**Application no: 22/02780/DISC**

**Location: Bicester Heritage, Buckingham Road, Bicester**

## **Lead Local Flood Authority**

**Date: 07/11/2022**

Title: Drainage Layout
Sheet 1 of 3

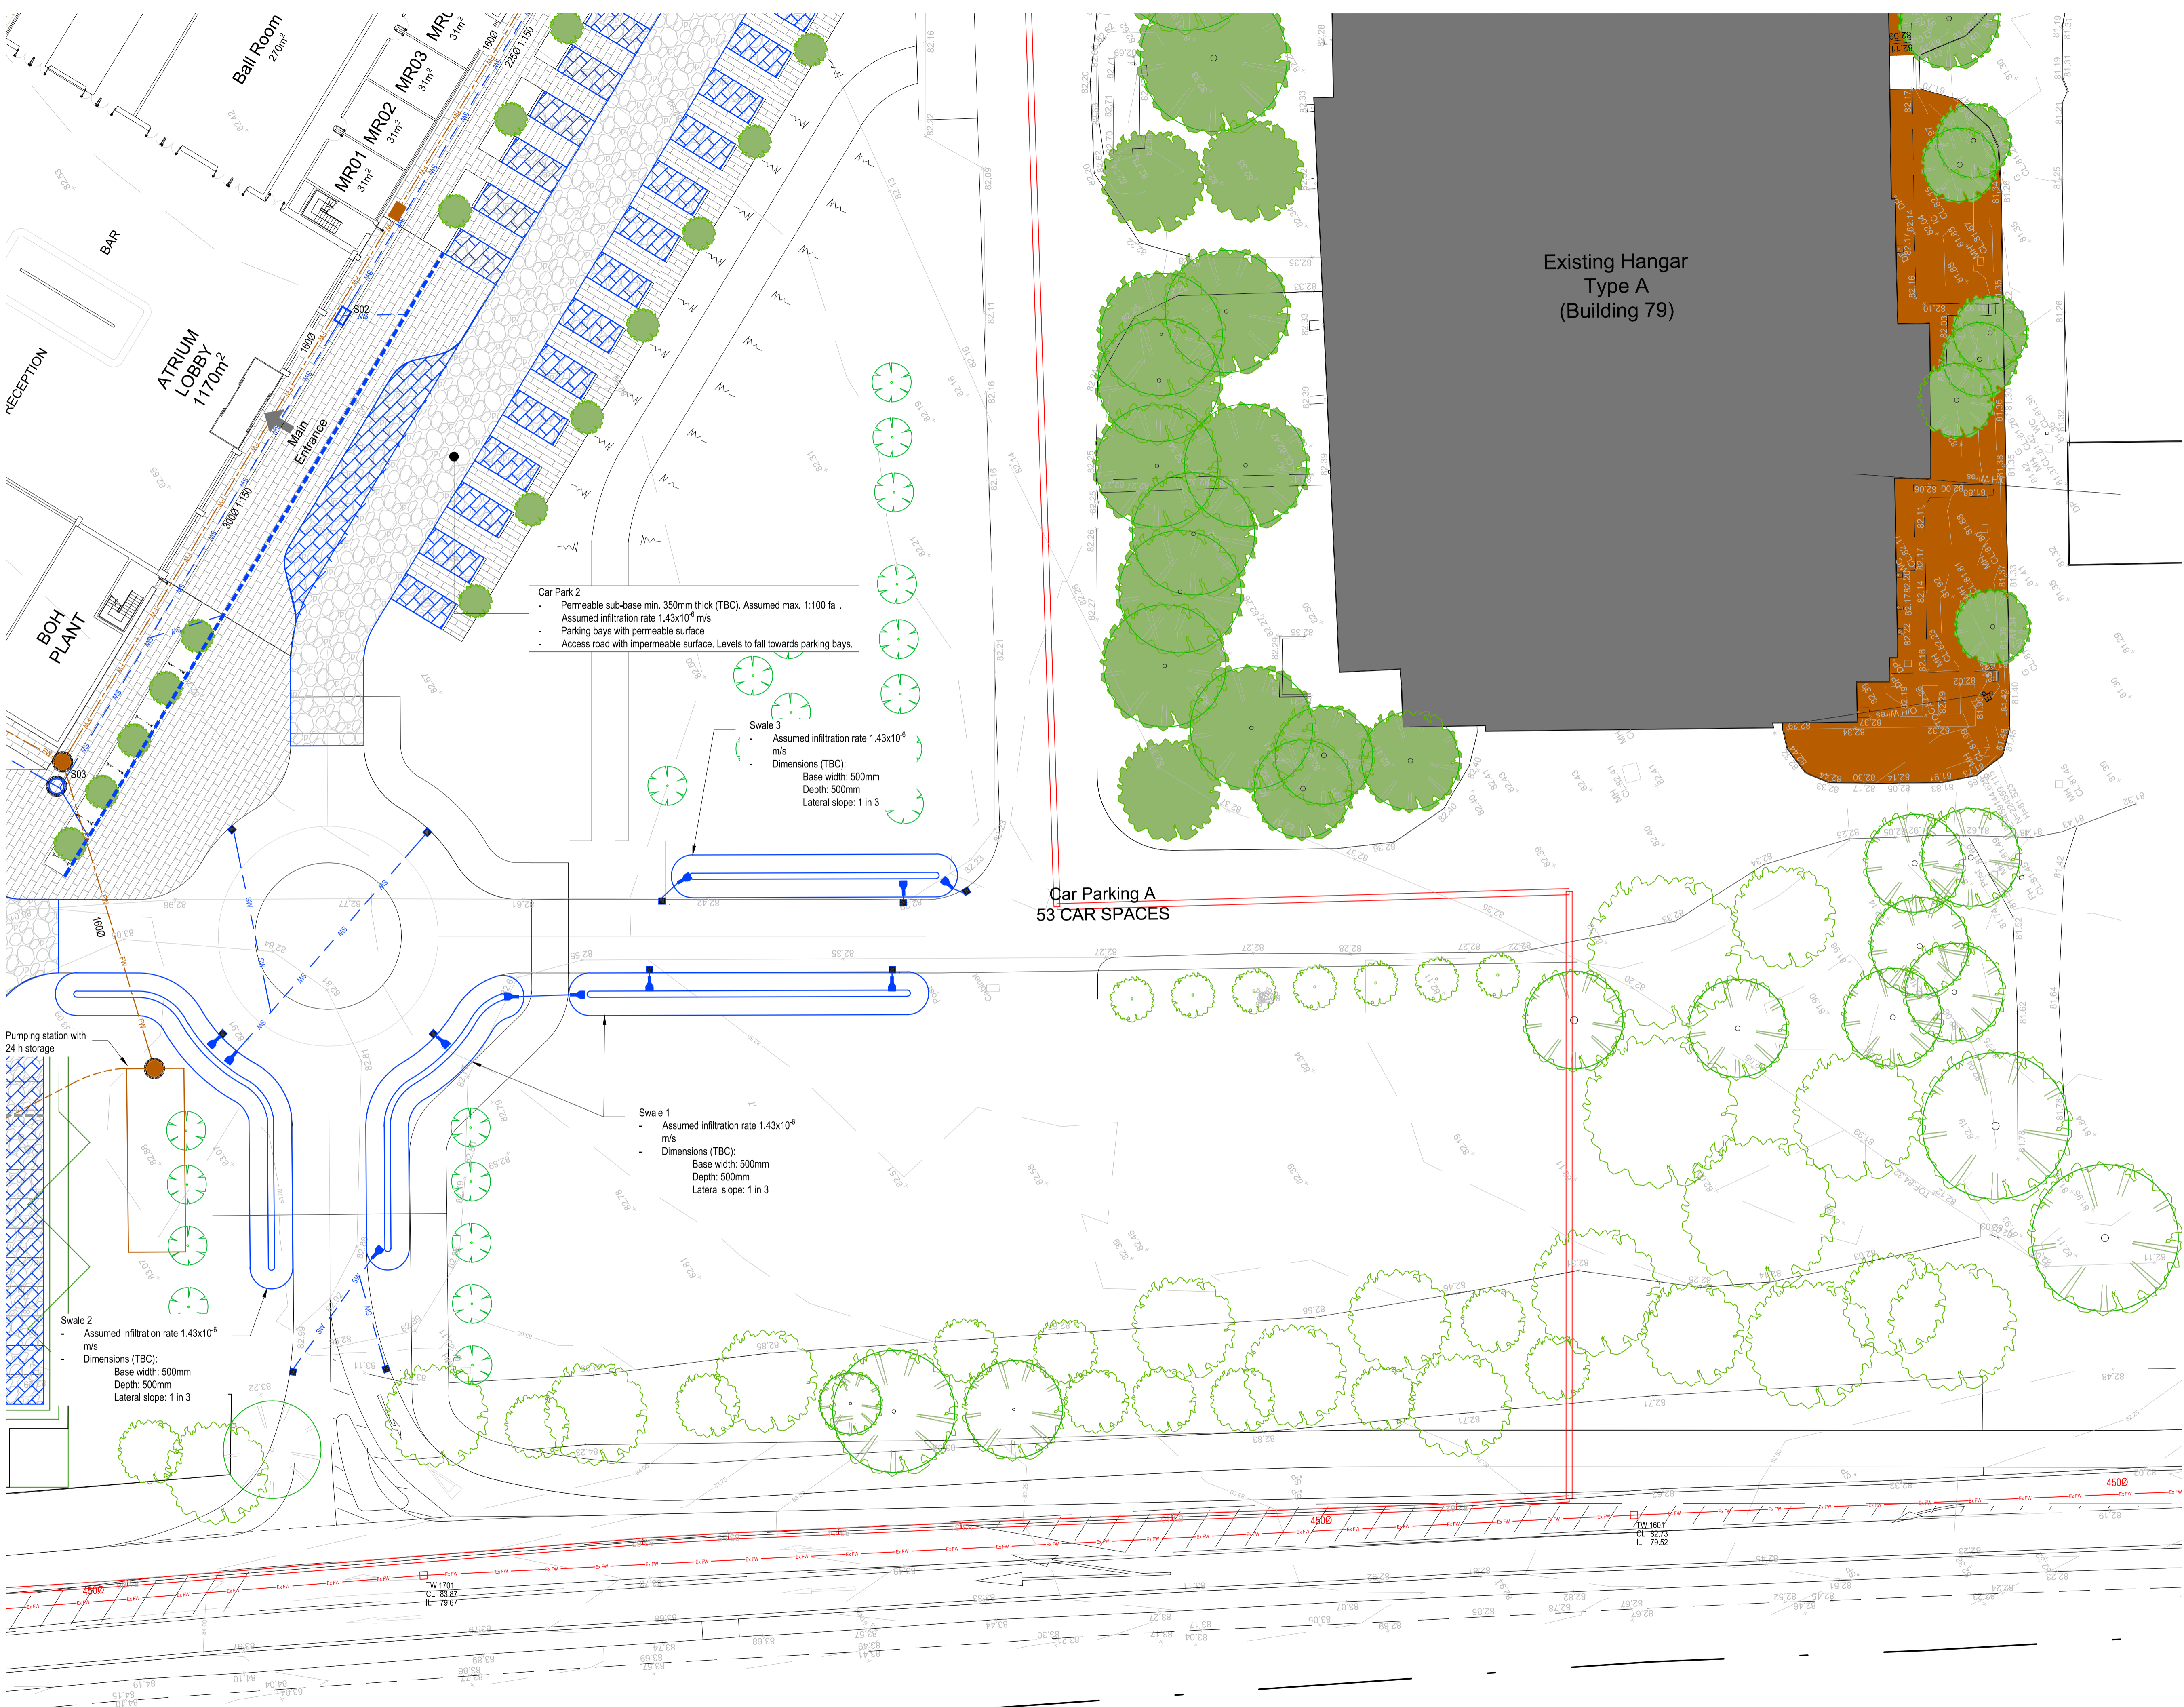
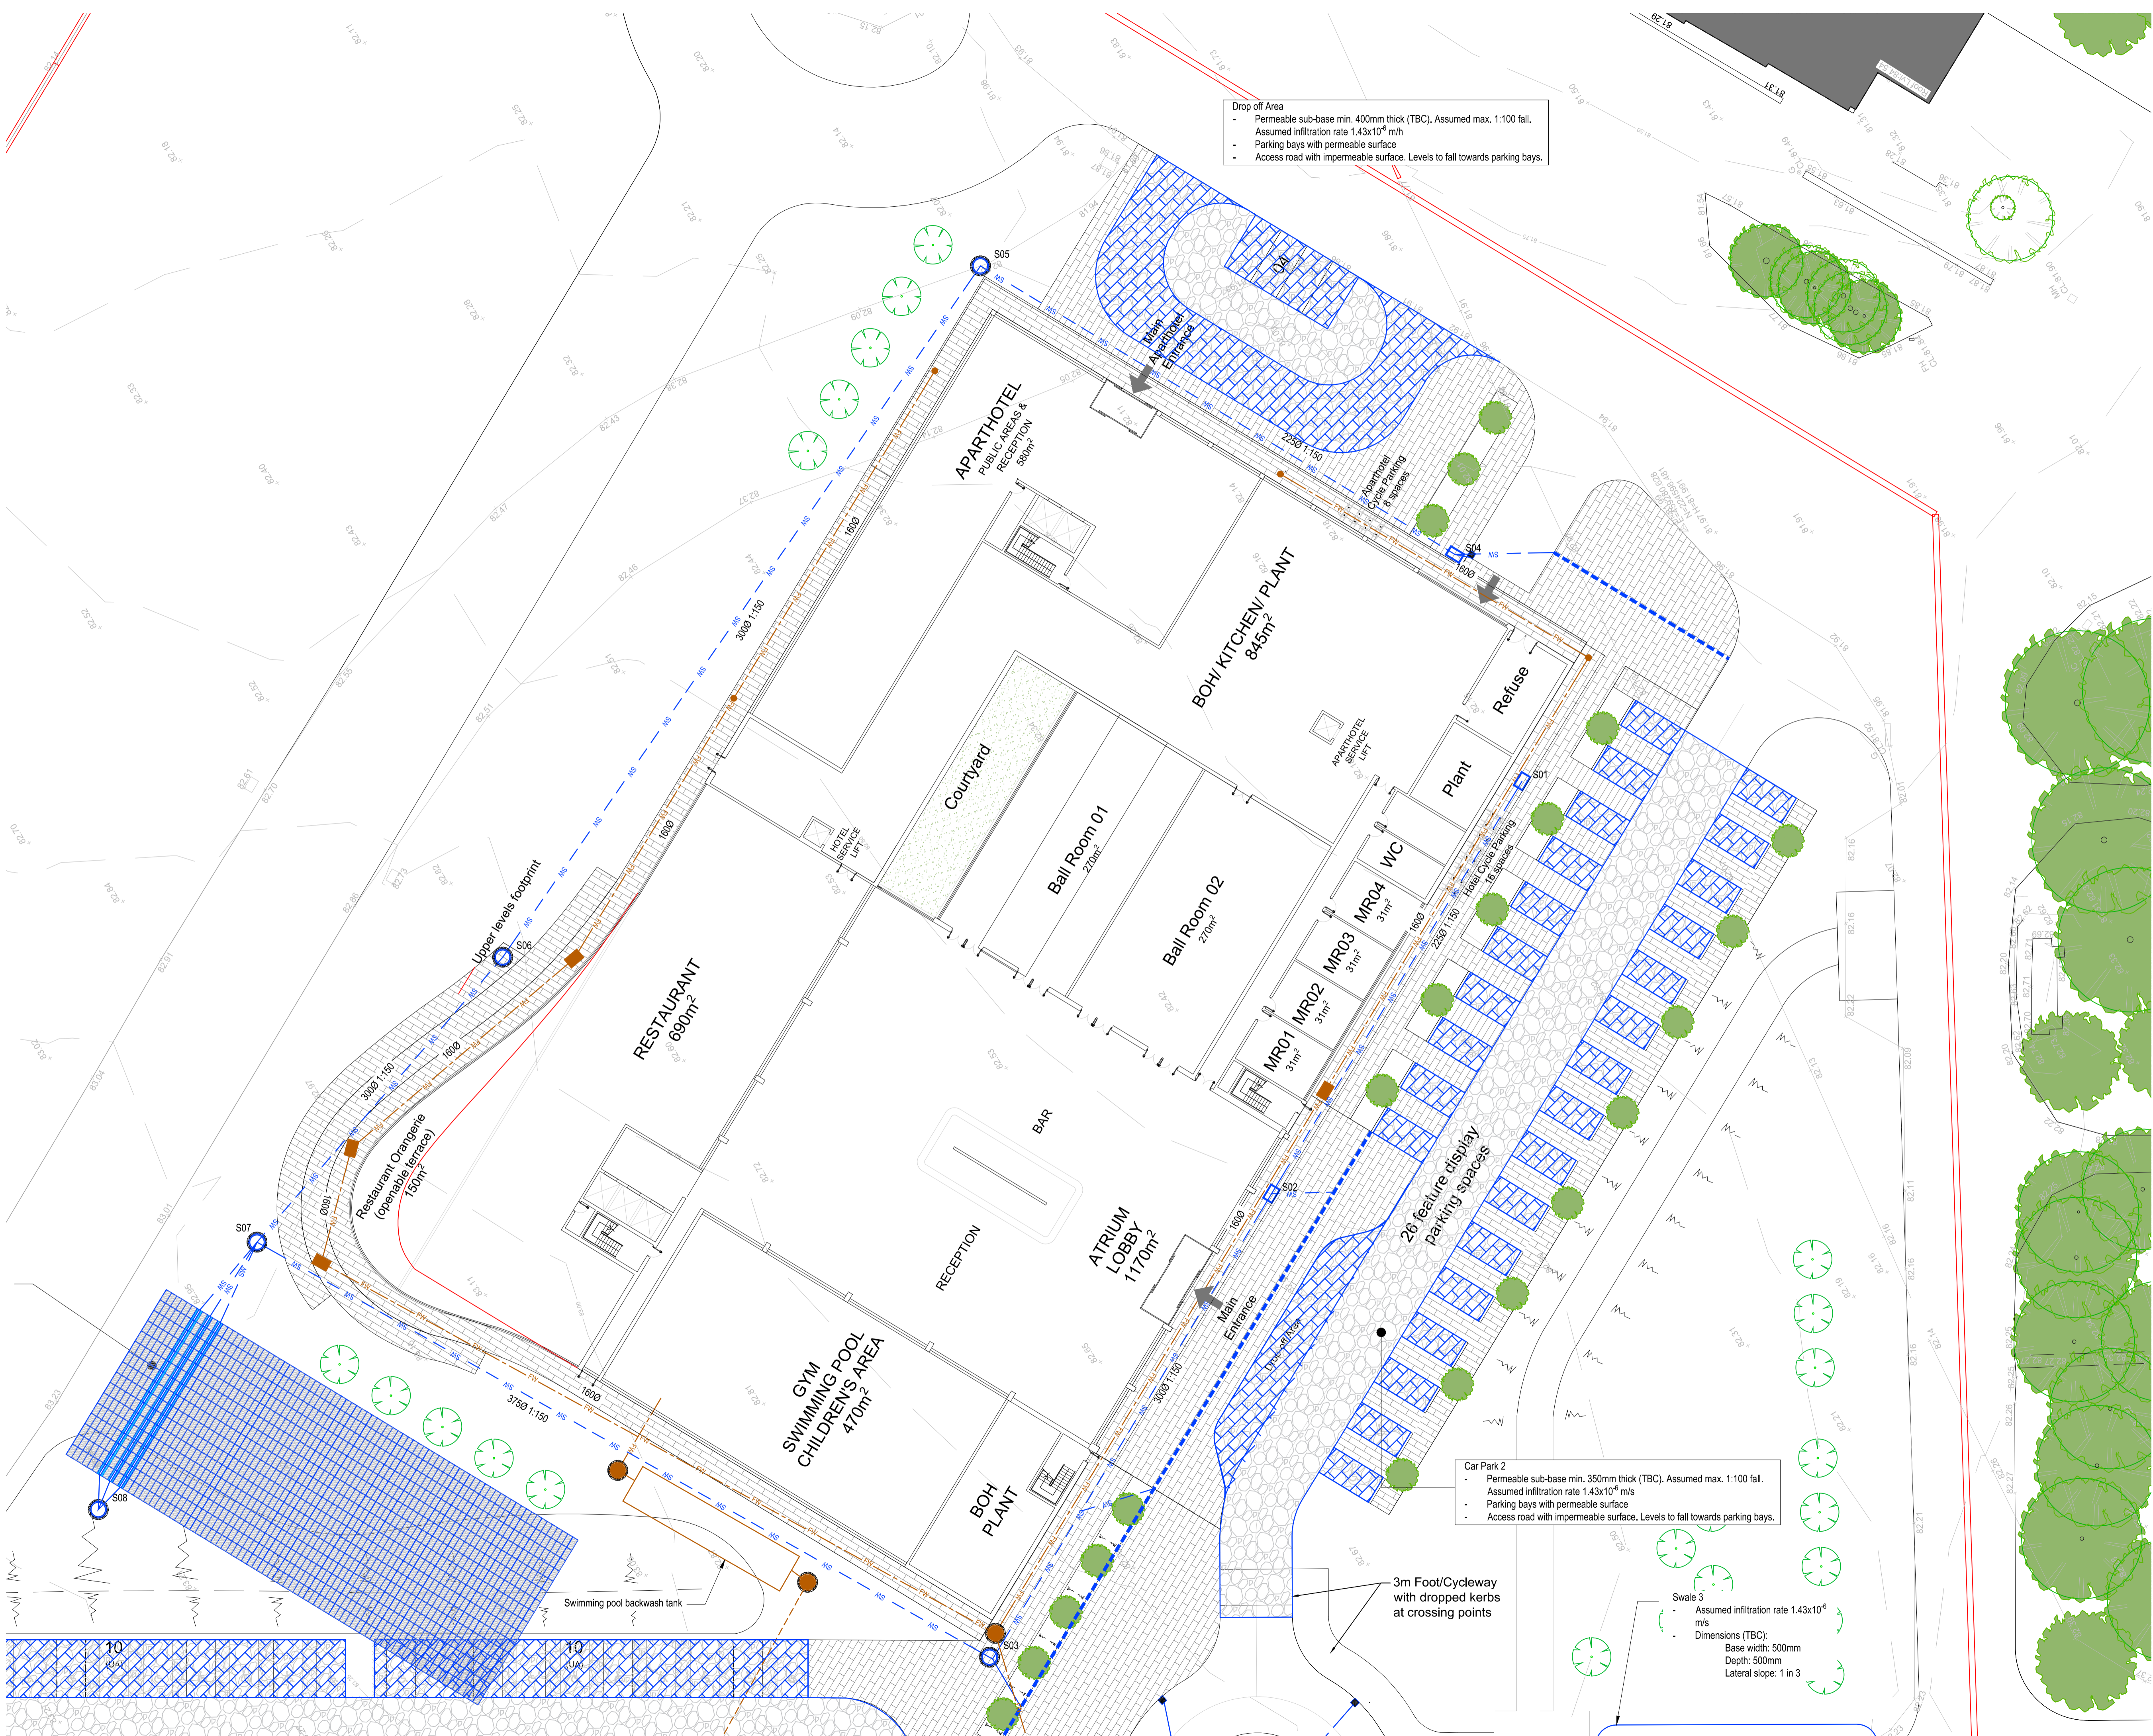
Provide discharge rates on the drainage plan for each proposed SuDS.

Provide surface water catchment plan which clearly indicates the extent of the impermeable areas and to which SuDS feature it will drain to. Currently some areas has been given but its unclear to which SuDS feature it will drain to.

Clarify the Key on the drainage plan, is the hard standing areas in grey permeable paving or will this drain towards the permeable paving in blue.

The drainage plan is not detailed, show the RWP pipes and how its connected to the SuDS.
